**WEST SUSSEX COUNTY COUNCIL
INFRASTRUCTURE CONSULTATION**

**SUBJECT: P/8/07 - Proposed additional car park adjacent to existing car park
(Departure from the development plan) – Discharge of Condition 4**

Church Farm, Land to the west of existing car park, Church Lane, Pagham

proposed extended carpark for
st. thomas à becket church,
pagham

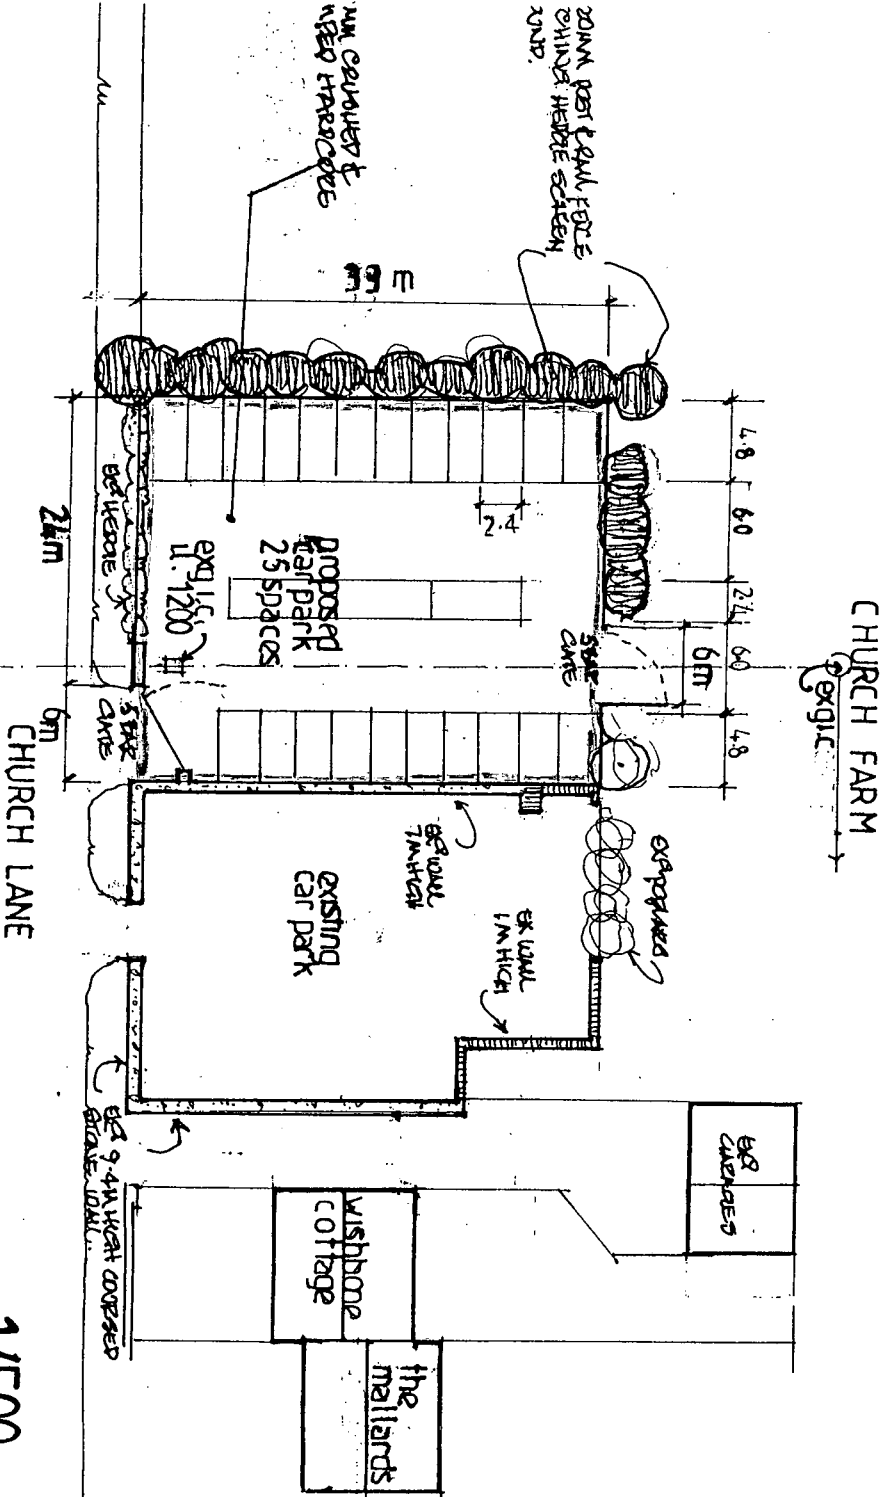
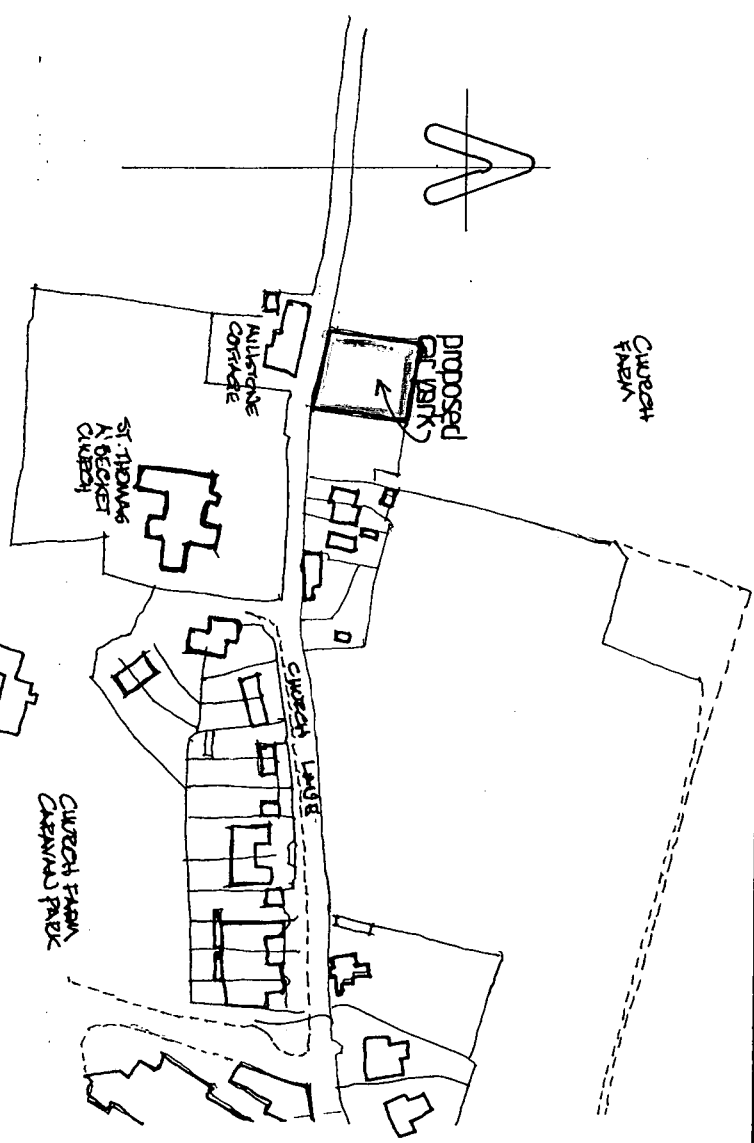
Condition 4 relates to the provision of 2metre by 45metre visibility splays at the new access. The plan submitted whilst showing the splays correctly, shows only 2metre by 40metre splays. No justification has been provided to the reduction of the splays from the standard specified within the condition or any reason given should the 2metre by 45metre splays not be achievable.

It would therefore be requested that the splays are lengthened to 45metres to meet the requirement specified by condition 4.
